Warwickshire County Council responses to EXA questions

Comments on any additional submissions received by Deadline 4

Drawing file: TR050007 / TR050007-002505-Hinckley NRFI Appendix 14 - Gibbet Hill Mitigation General Arrangement.pdf

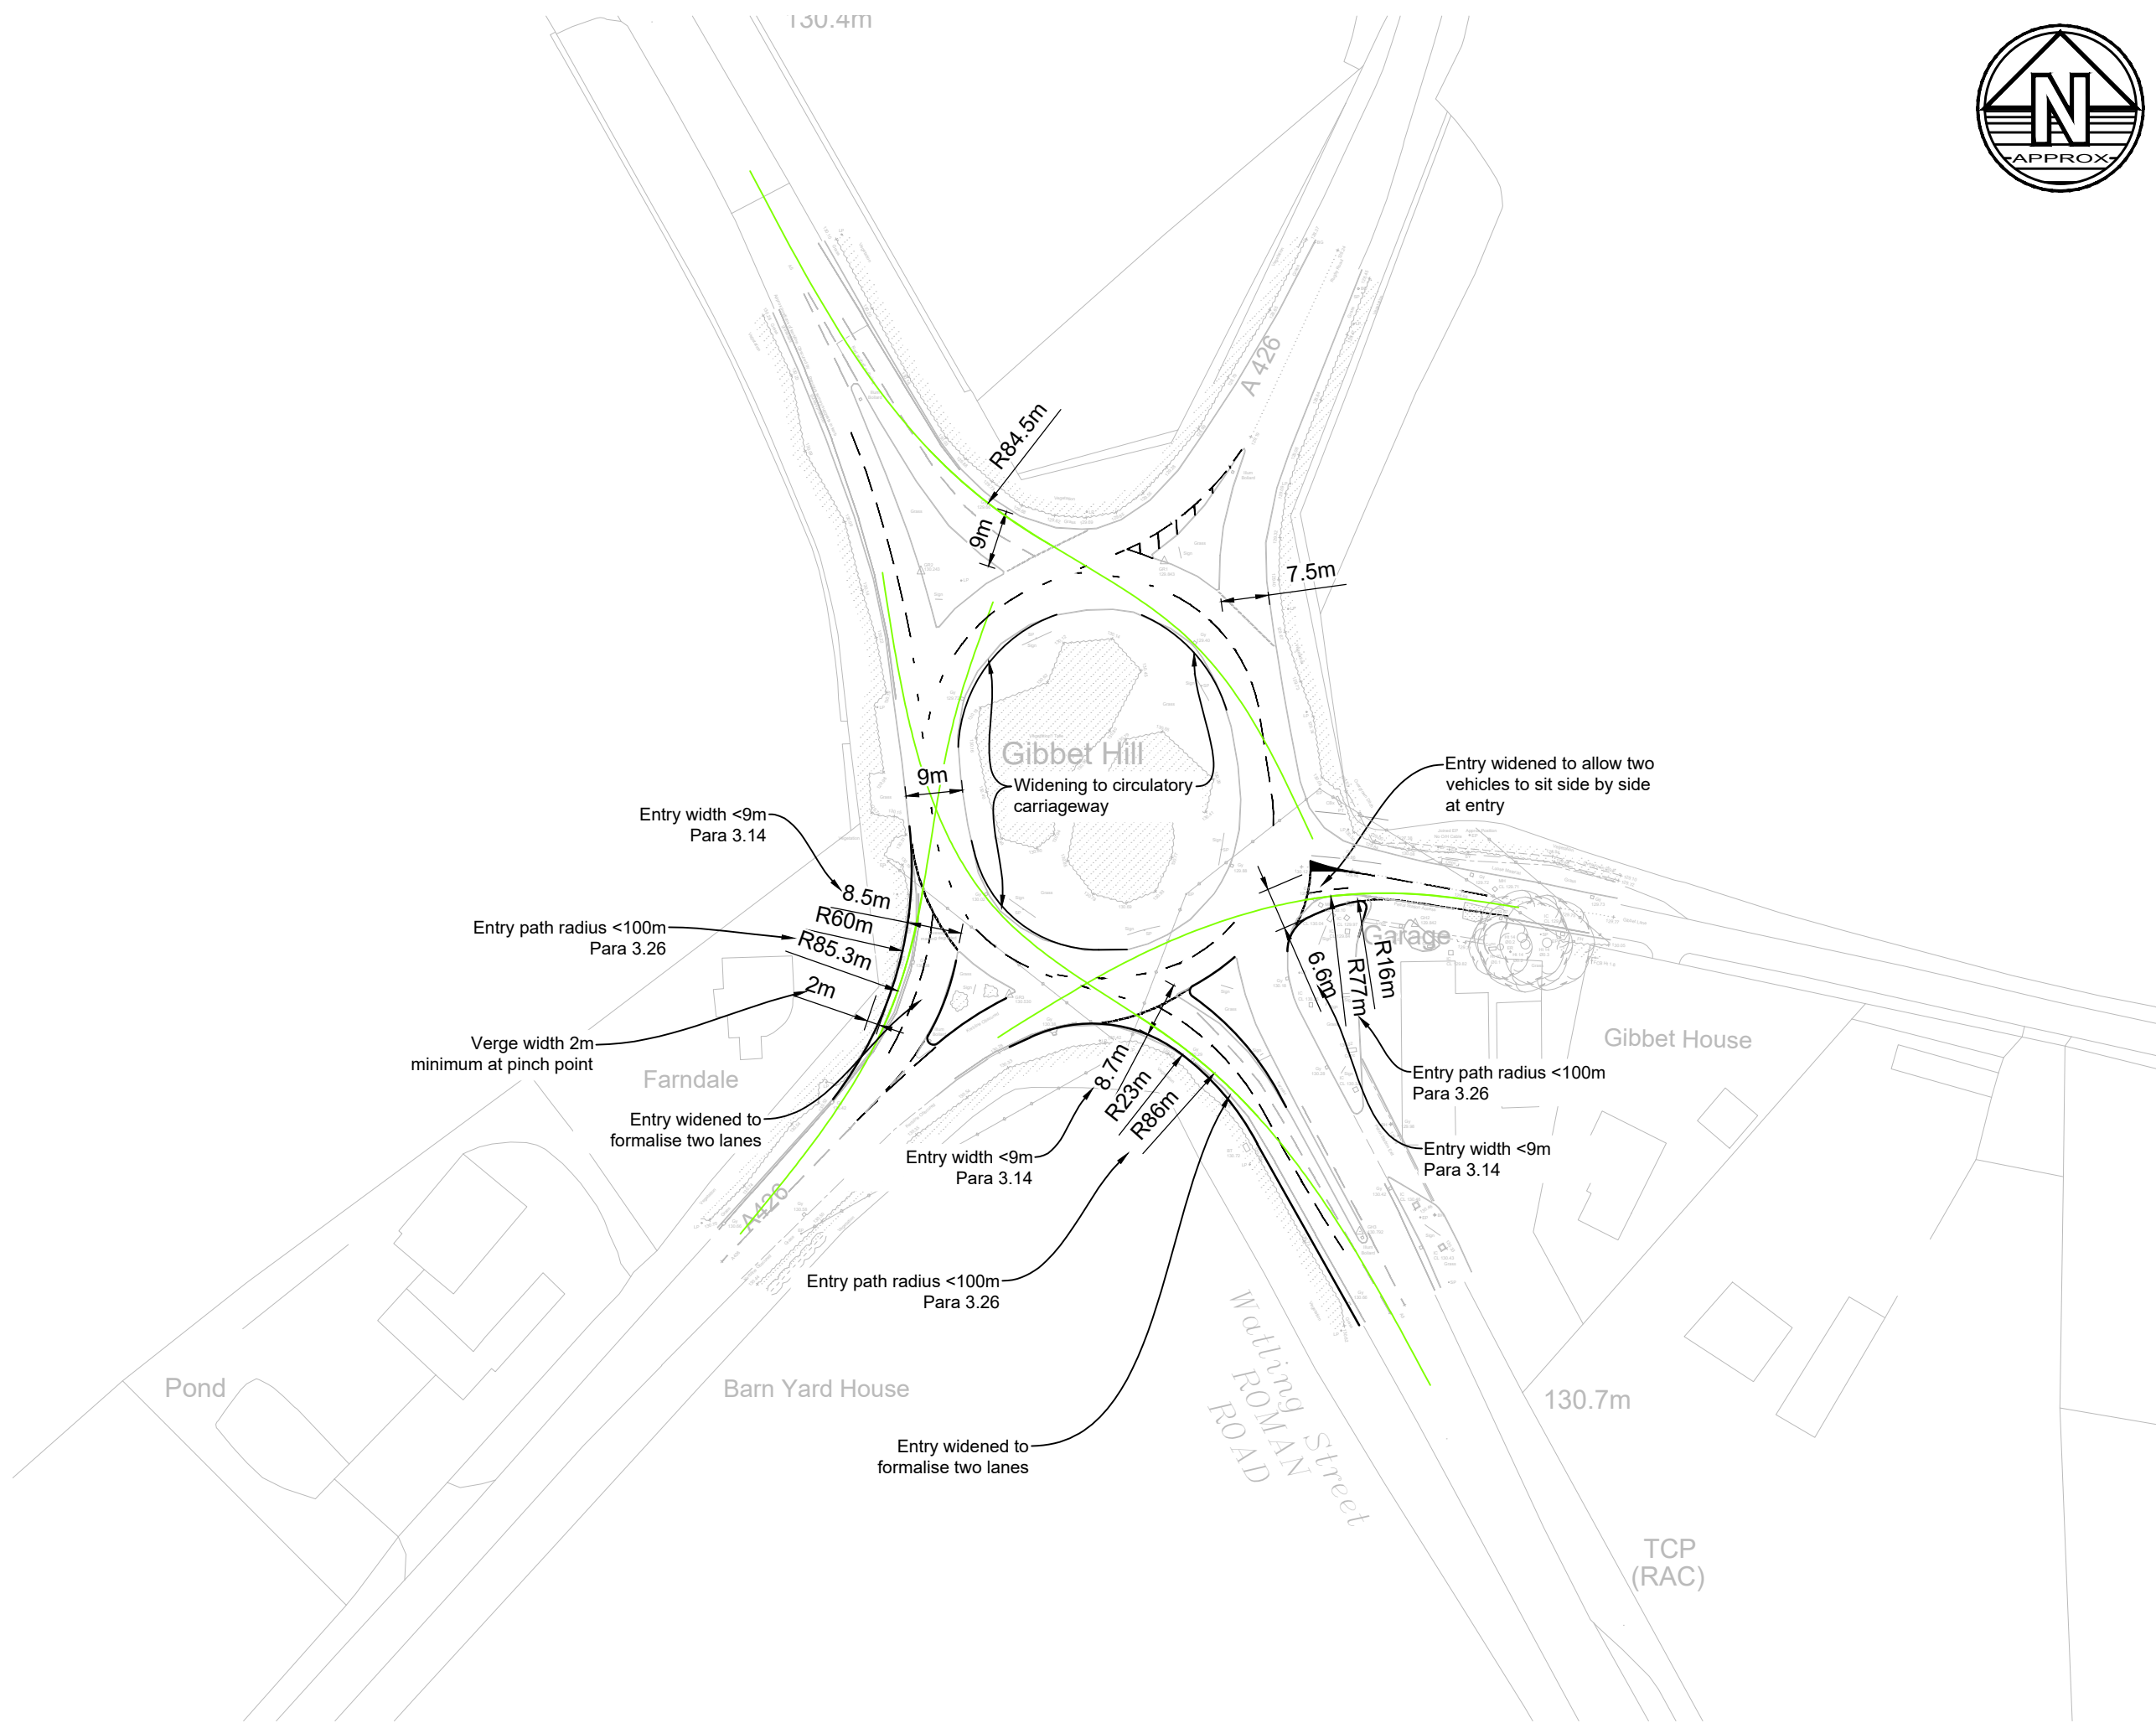
| Examination Ref | Question | WCC Response | Applicant's Response |
|-----------------|----------|---|---|
| | | <p>necessarily be suitable to address the true impacts of the development.</p> <p>WCC will continue to discuss this issue with the applicant and will update at each Deadline.</p> <p>It is noted that to date a VISSIM assessment of Gibbet Hill has not been carried out by the applicant. WCC's previous comments from Deadline 1 are listed below and these set out why an assessment is necessary to enable a CIL compliant decision to be made in respect of any potential contributions in mitigation of development impacts.</p> <p>3.21. -- Whilst BWB has noted in its response to point 19 in HNRFL-BWB-GEN-XX-RP-TR-0031-Rev-P01 that there is not full correspondence between the 18 entry points identified within the VISSIM model and the traffic flows derived from PRTM, Warwickshire County Council consider that it is still important for the VISSIM to be used to assess development impact for the reasons set out below.¶</p> <ul style="list-style-type: none"> • -- National Highways does not have a committed scheme at this junction as highlighted previously and therefore the baseline position for the modelling must be the existing non-signalised junction arrangement (i.e., a Do-Nothing).¶ • -- Blocking back towards M6 Junction 1 along the A426 and platooning of traffic between M6 Junction 1 and the Gibbet Hill junction can only be considered within the VISSIM model.¶ • -- Whilst Warwickshire County Council understands that flow correspondences may only exist across 8 loading points, we do not necessarily consider this to be a limitation which invalidates the use of the VISSIM model.¶ • -- For example, if the loading points within the VISSIM model which correspond to the PRTM data include the A5 (2), the A426 north and south (2) the M6 (2) and Gibbet Lane (1) then there is sufficient network correspondence to assign the development trips across the study area from the PRTM outputs.¶ • -- Warwickshire County Council does not require the interaction on the minor roads (i.e., Lutterworth Road or Arthur James Drive) to be considered in terms of changes in development flows and, as such, impacts at these locations can still be considered, particularly in the context of the effects arising from delivery of any proposed mitigation at Gibbet Hill.¶ <p>3.22. -- Therefore for these reasons Warwickshire County Council does not accept the modelling or proposed mitigation at this location, and requires the VISSIM modelling to be carried out.¶</p> | <p>Discussions have continued with the Applicant team, understand that they do not consider it proportionate to undertake VISSIM modelling for this junction. However for the reasons set out previously, and that the ARCADY modelling results do not reflect observed conditions, WCC consider a VISSIM assessment the only fair and reasonable way to assess impact and therefore develop a CIL compliant mitigation scheme.</p> |
